WEST SUSSEX COUNTY COUNCIL CONSULTATION

TO:	Arun District Council FAO: Amber Willard
FROM:	Highways, WSCC
DATE:	01/06/2018
LOCATION:	31 North Ham Road, Littlehampton, BN17 7AS
SUBJECT:	LU/81/18/HH Single storey rear extension & new vehicle access.
DATE OF SITE VISIT:	n/a
RECOMMENDATION:	☒ Advice ☐ Objection ☐ Modification ☐ No Objection ☒ More Information ☐ Refusal
S106 CONTRIBUTION TOTAL:	n/a

DRAWING	SCALE
BLOCK PLAN	1/200
DATE: MARCH 2018	
DRAWN: T. Murray	
DRAWING: 18/07/3	REVISION:

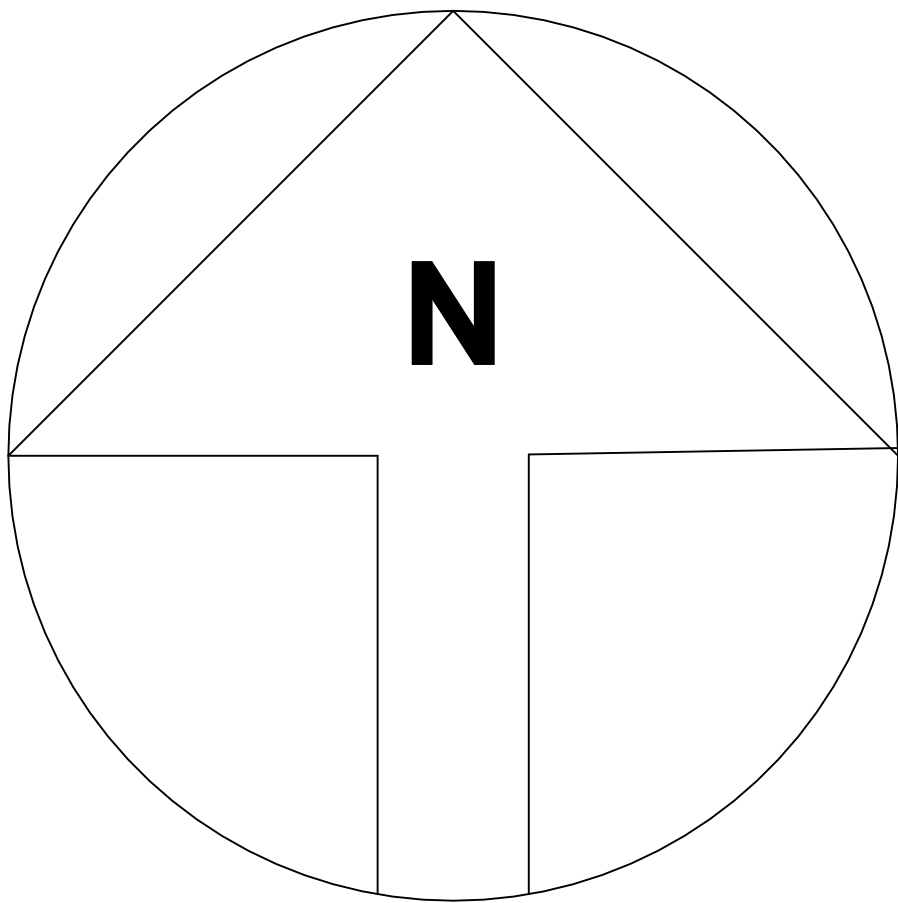
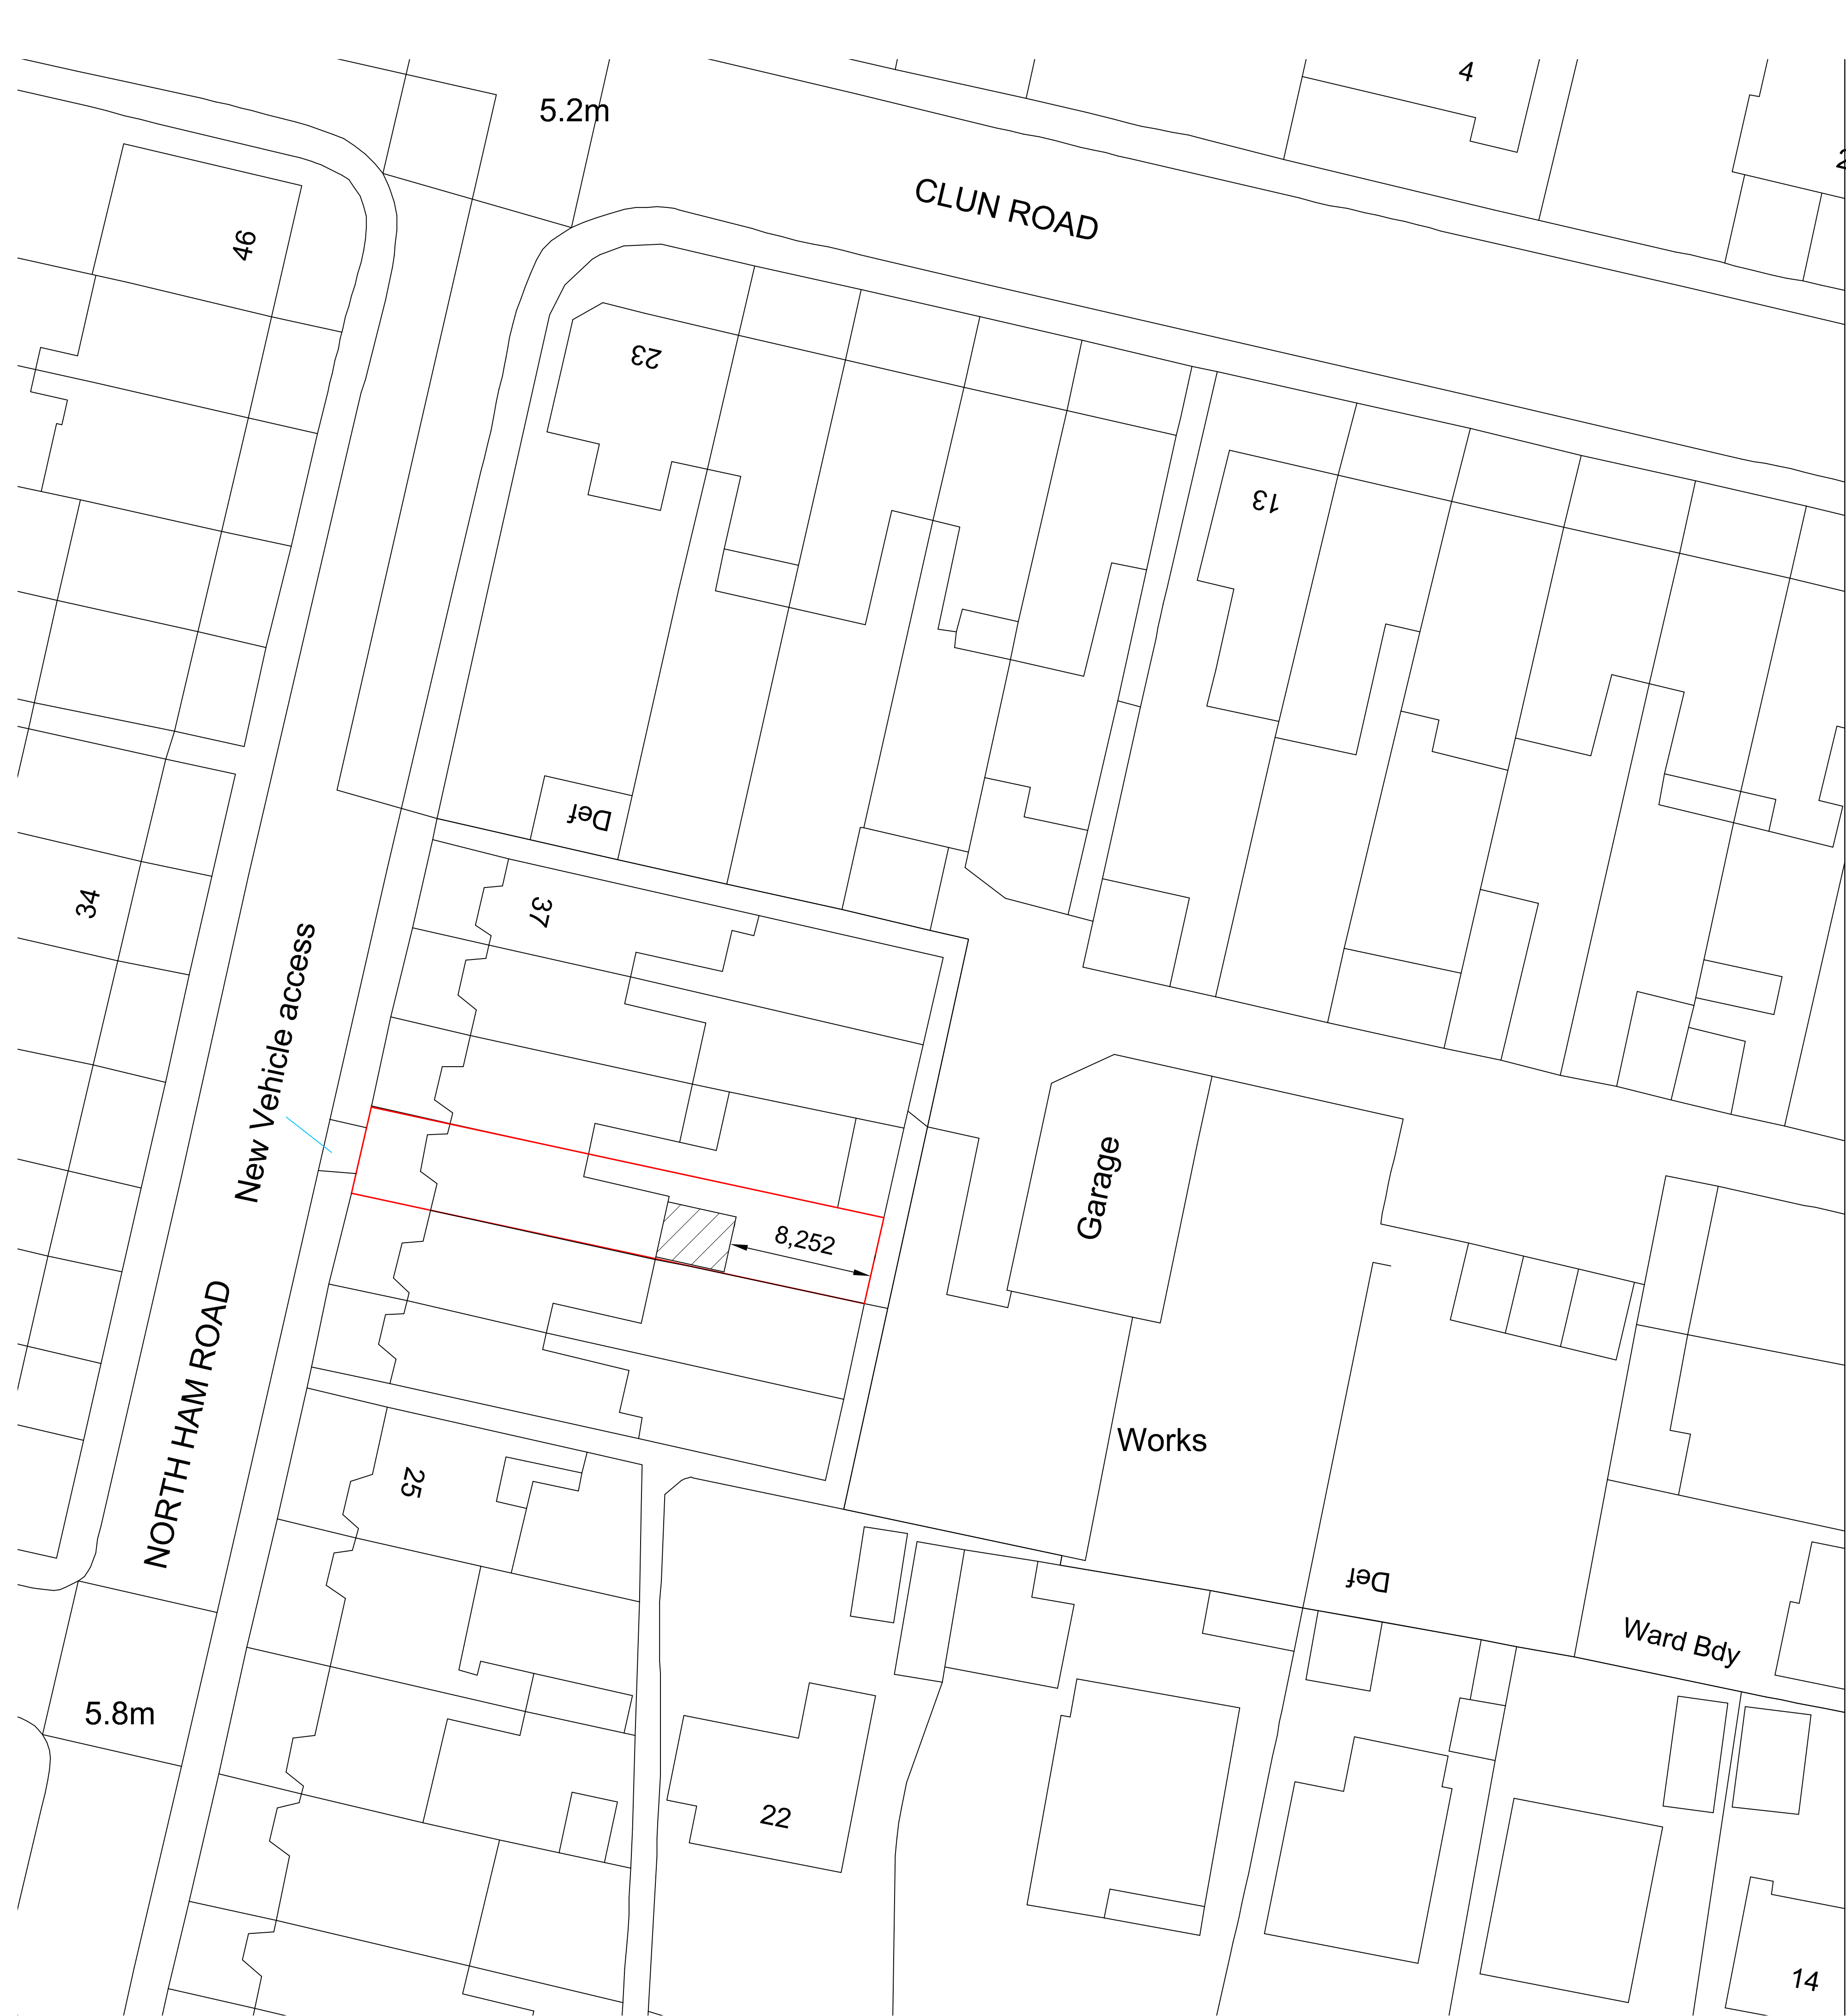
No plans have been provided demonstrating in any detail the hardstanding area which would be used for parking of a vehicle. Before the Local Highways Authority can provide advice on this application a plan demonstrating the size of any proposed hardstanding area would be required.

The applicant would be advised that 2.4 x 4.8 metres of hardstanding is required to fully remove a vehicle from the carriageway / footway. Parallel spaces should measure 2.4 x 6 metres.

Scaling OS mapping it does not appear that a vehicle could be parked in the frontage without overhanging the footway.
